# The Planning Inspectorate

Our Ref: EN020021

### **Application by SP Manweb for an Order Granting Development Consent for the Reinforcement to the North Shropshire Electricity Distribution Network**

#### **Advice following issue of decision to accept the application for Examination**

Document Reference: 2.2.0 - 2.2.16  
Land Plans

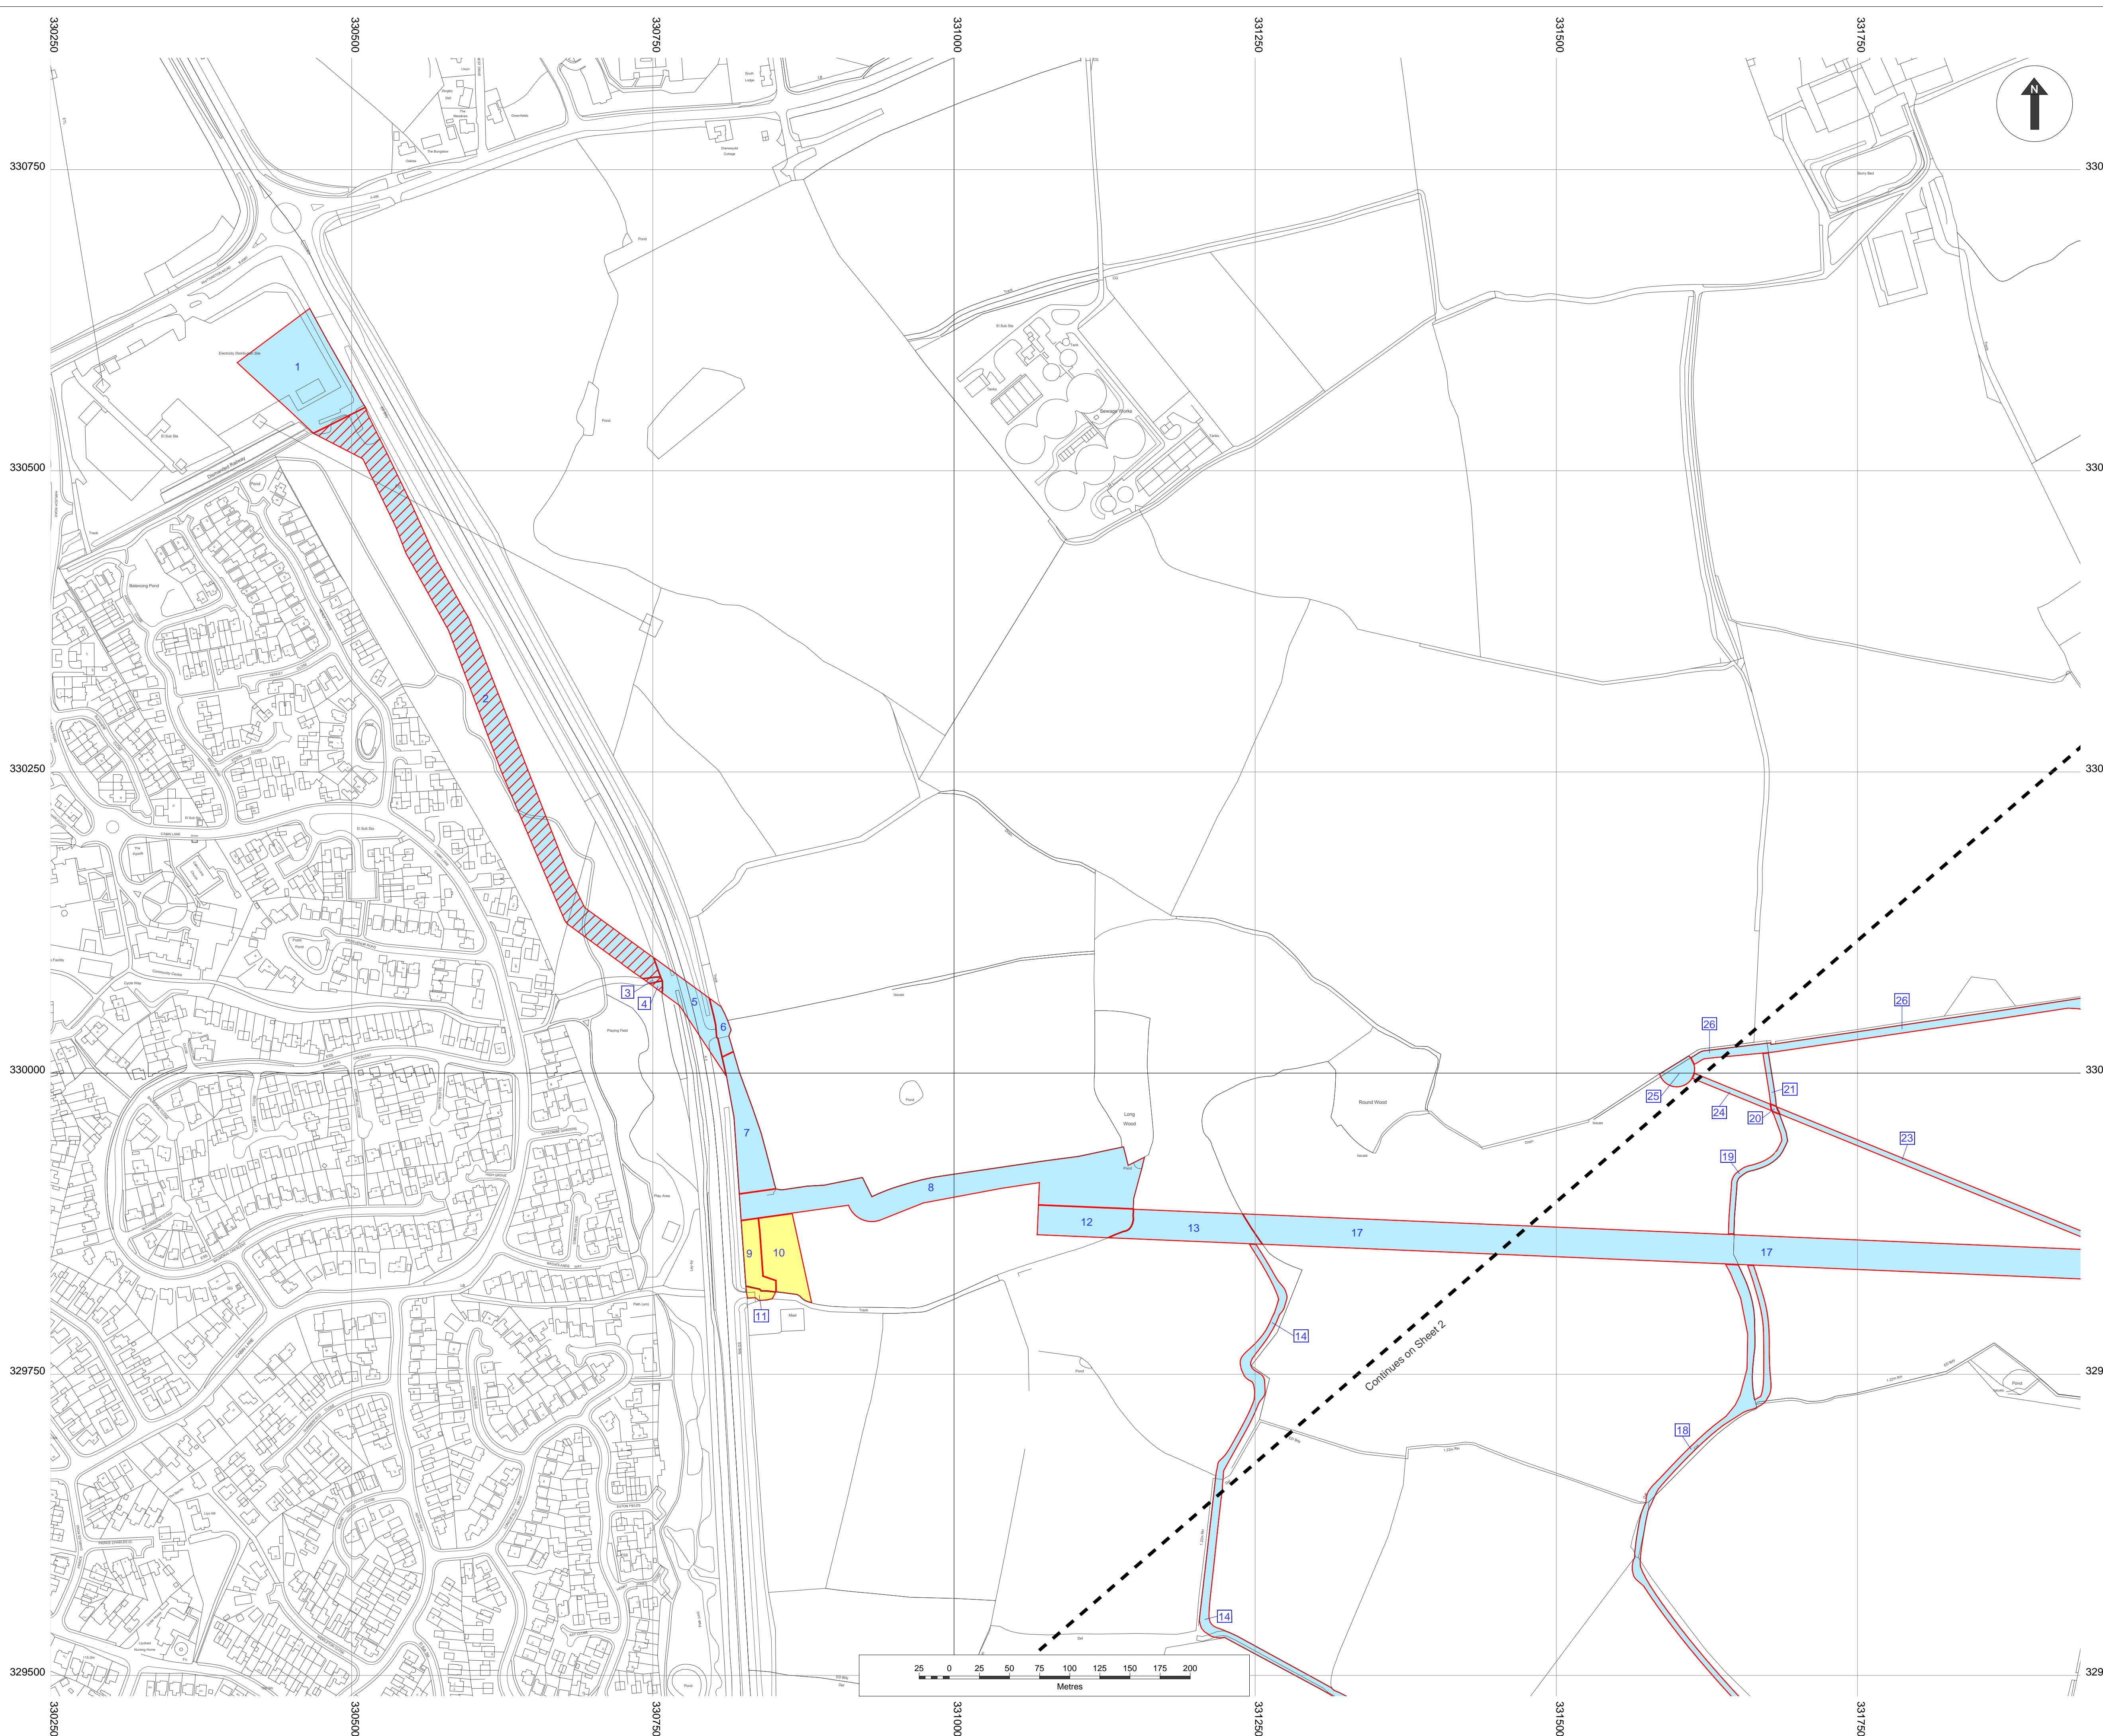
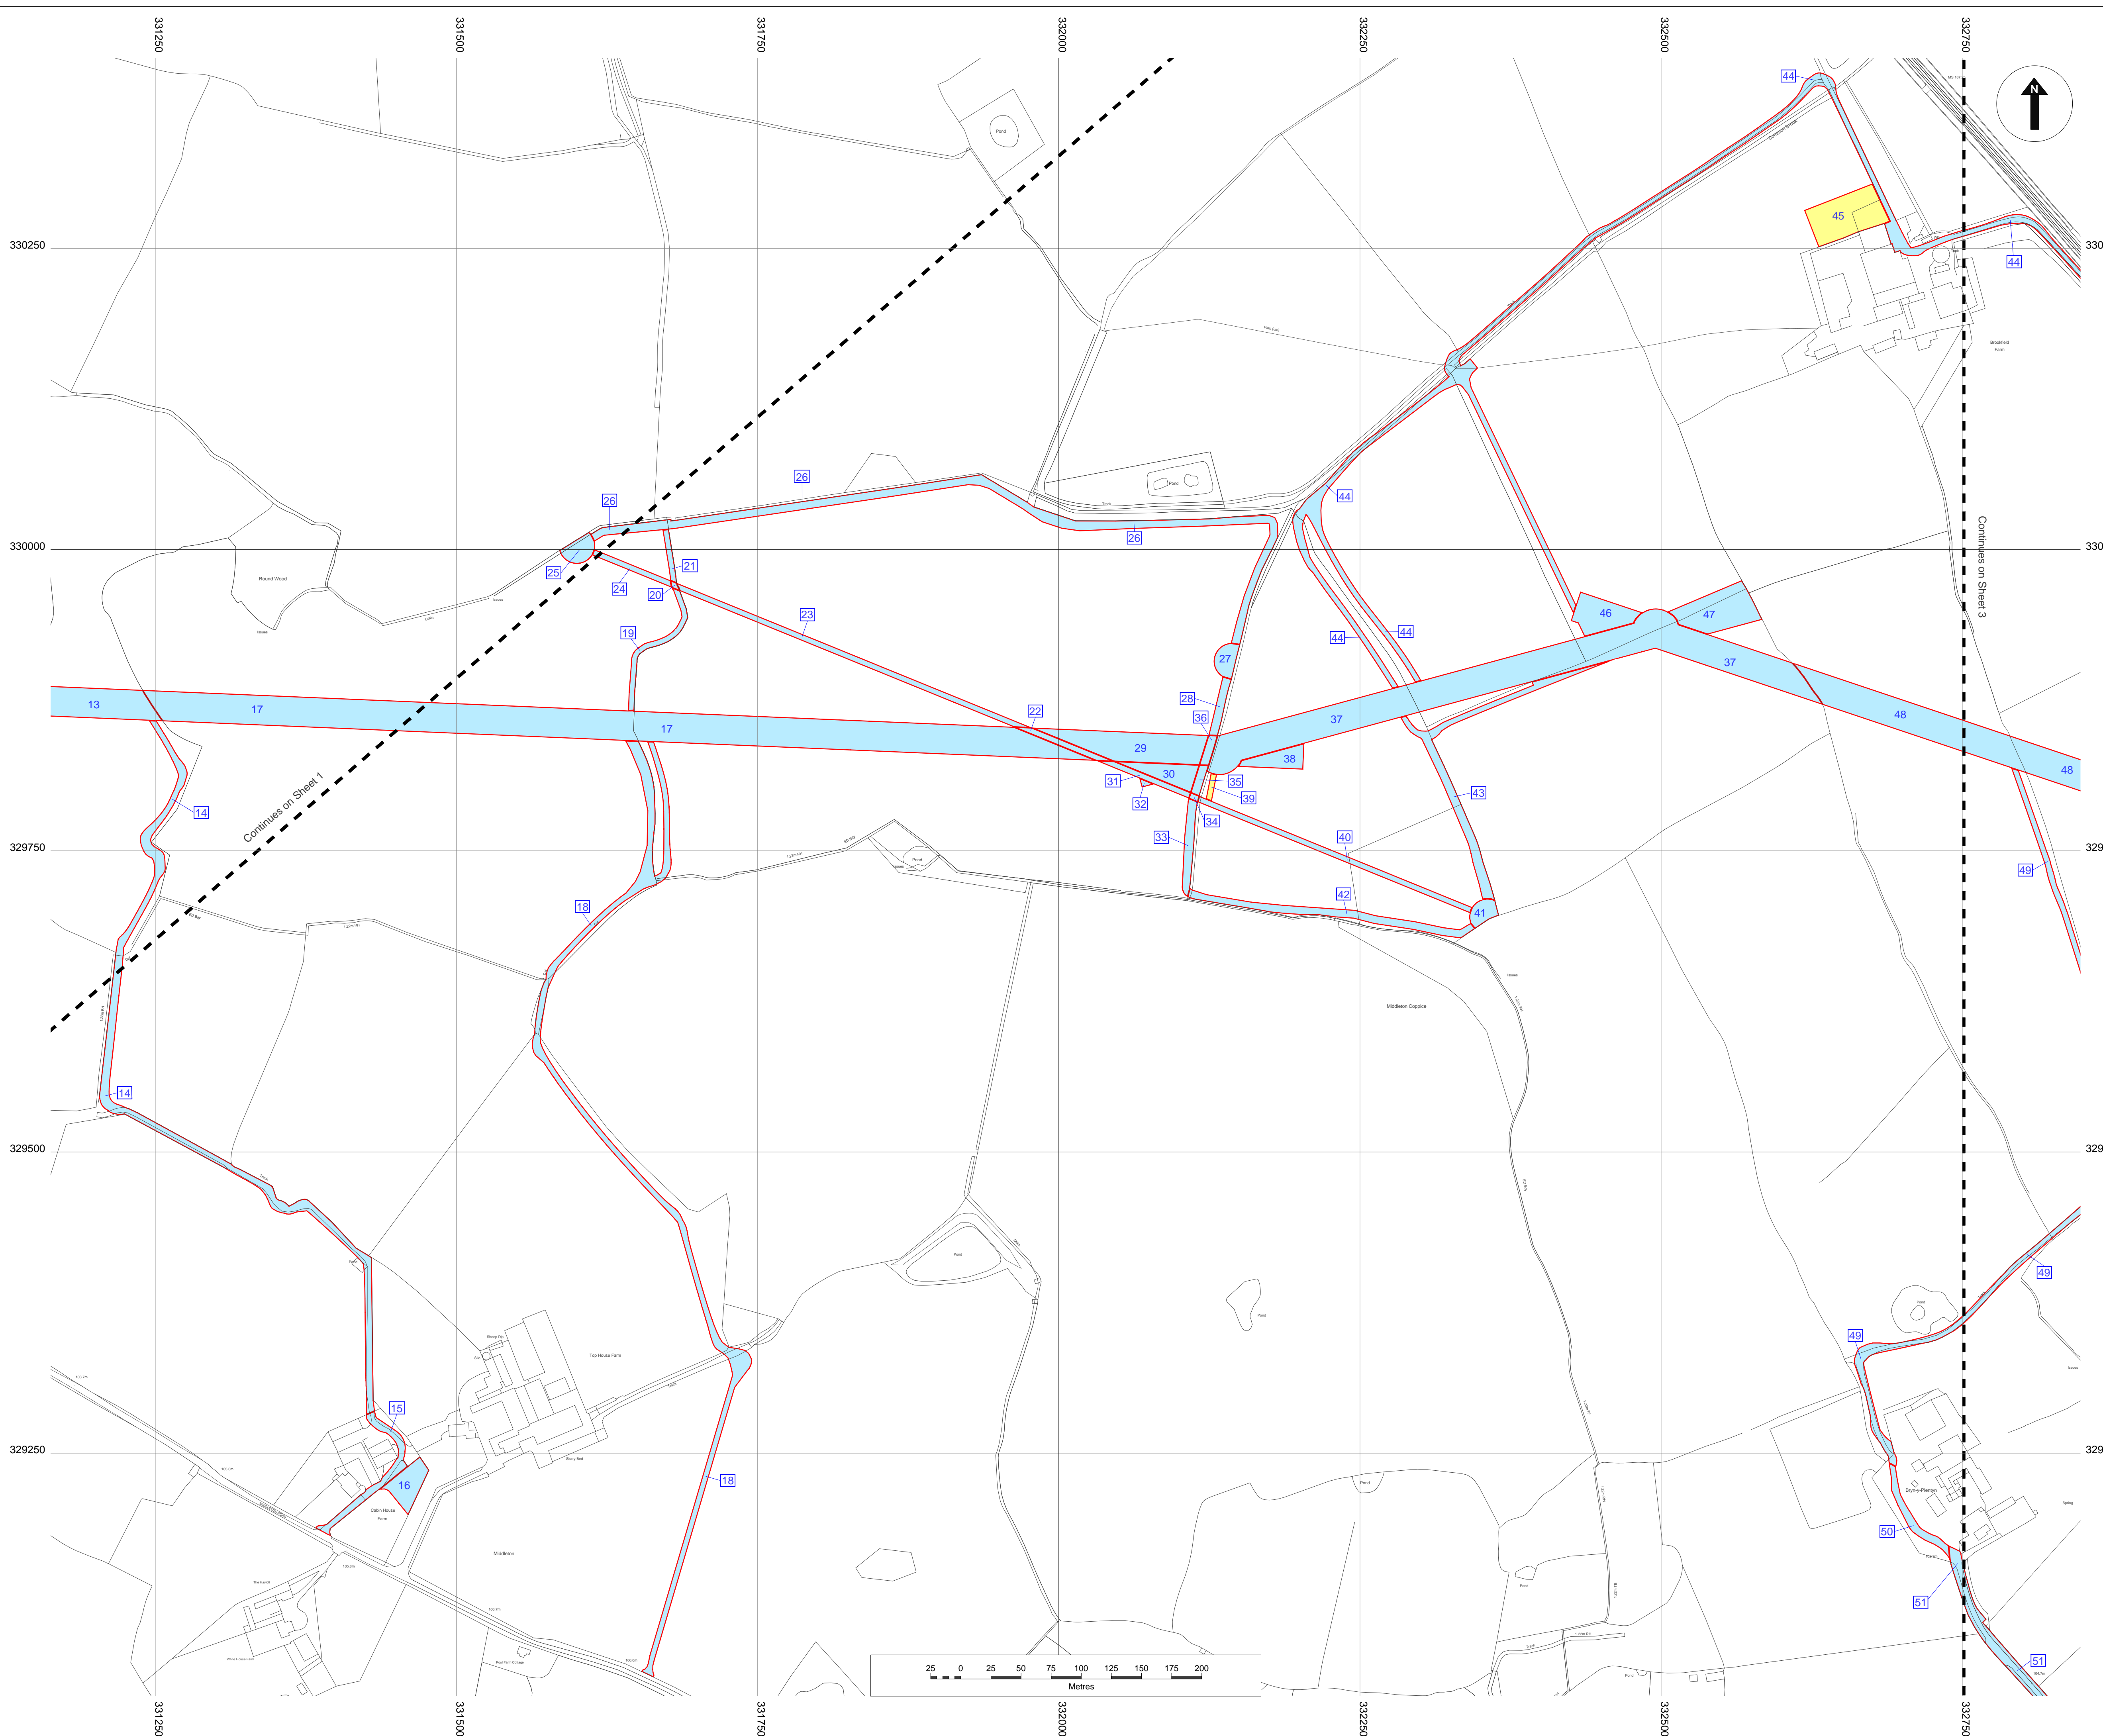
The plots coloured yellow on the Land Plans are described in the legend as “*Order Land – temporary rights (construction only) to be compulsorily acquired, and temporary use of the land, and in relation to which it is proposed to suspend or extinguish easements, servitudes and other private rights*”. It is not clear from this whether it is temporary possession or compulsory acquisition of permanent rights to be used temporarily which is intended by the Applicant in relation to specific plots. The Applicant is therefore requested to clarify the precise rights it is seeking over each plot marked yellow on the Land Plans.

Some discrepancies were found between the colour of some plots on the Land Plans and the description of rights the Applicant is seeking over that land in the Book of Reference. The Applicant is advised to carry out a full review of the Land Plans and the Book of Reference and ensure that all land interests are clearly informed about the precise nature of rights the Applicant is seeking over their land.
